**Our ref:** RA/2023/145993/03-L01  
**Your ref:** 2023/91491

**Date:** 15 January 2025

**ERECTION OF 61 AGE-RESTRICTED APARTMENTS WITH ANCILLARY ACCOMMODATION INCLUDING SEPARATE RESIDENTS LOUNGE AND MANAGER FACILITIES AND ASSOCIATED EXTERNAL WORKS, INCLUDING THE ERECTION OF ACCESS BRIDGE AND RIVERSIDE WALK FEATURING TWO PEDESTRIAN BRIDGES (WITHIN A CONSERVATION AREA) (AMENDED PLANS SUBMITTED). PRICKLEDEN MILLS, WOODHEAD ROAD, HOLMFIRTH, HD9 2JU**

PROPOSED SITE PLAN

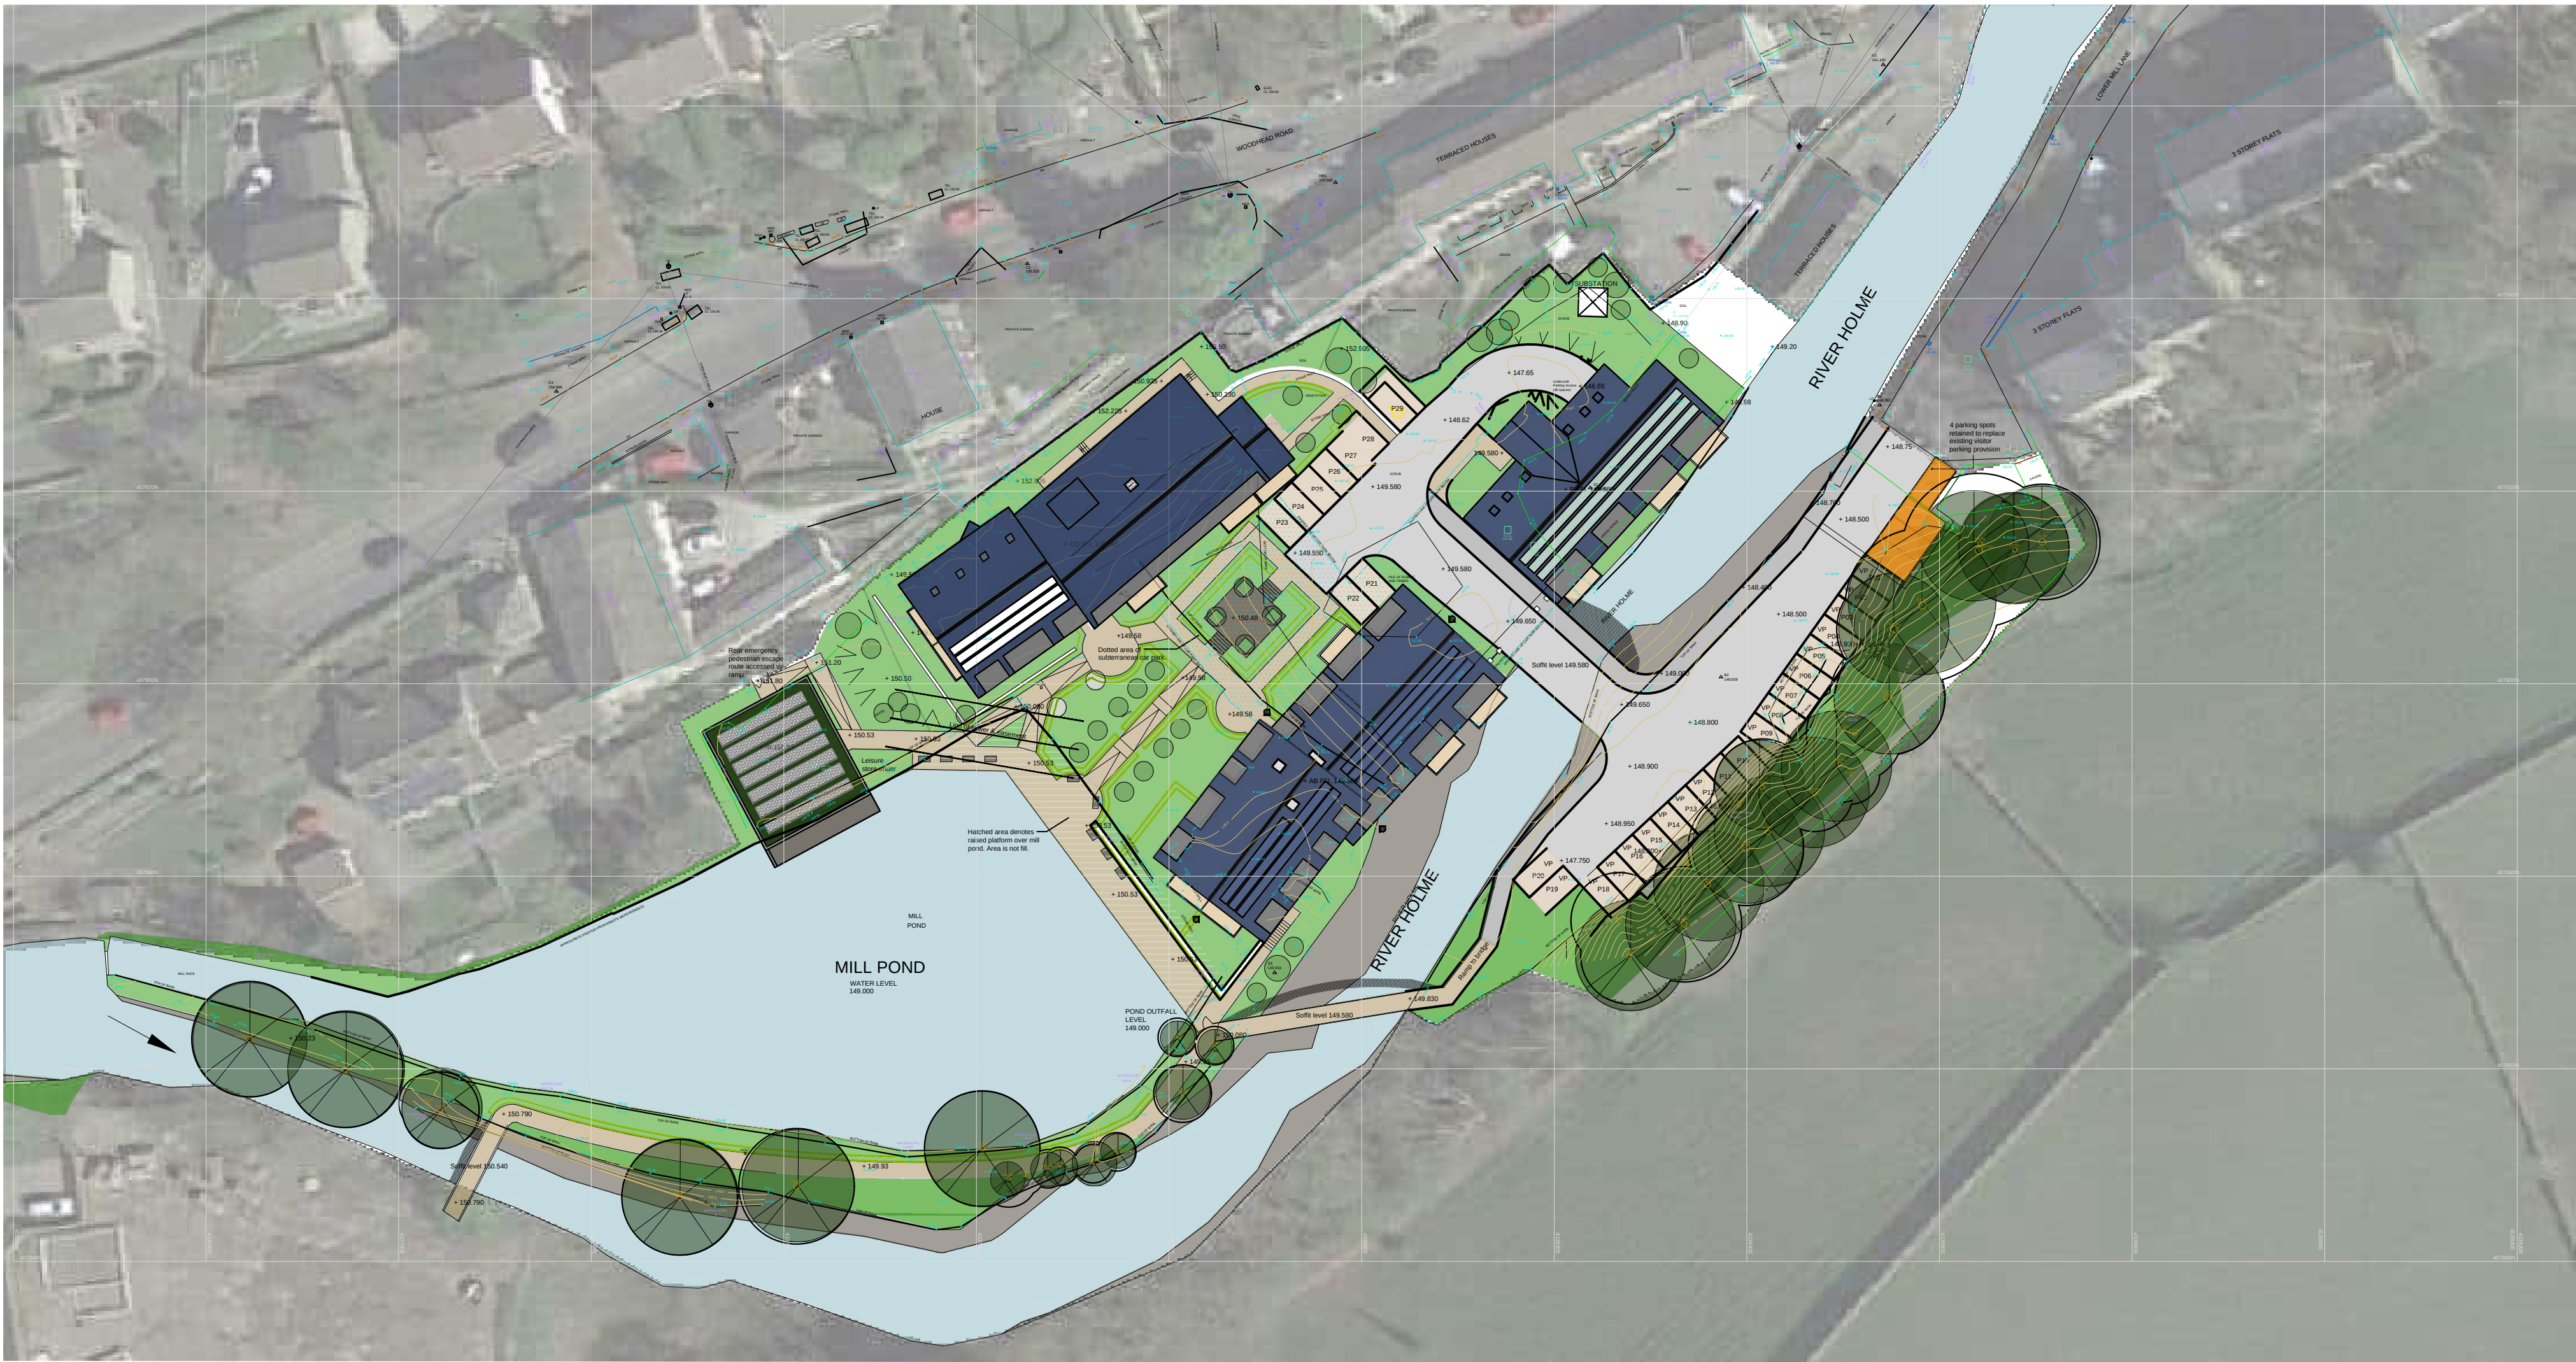
- The site plans show two new bridge crossings over the River Holme, the applicant still has not provided any detailed information on the design of the proposed bridge crossings and associated riverbed/bank reinforcements that are required.

- For both bridges, please provide detailed plan-view and cross-section view drawings showing their design and any associated reinforcement.
  - To ensure minimal ecological disruption, we require bridge crossings to be a clear-span (no in-channel supports) design with abutments that are sufficiently set back from the riverbank. Where possible, please show that these requirements have been incorporated into the design.
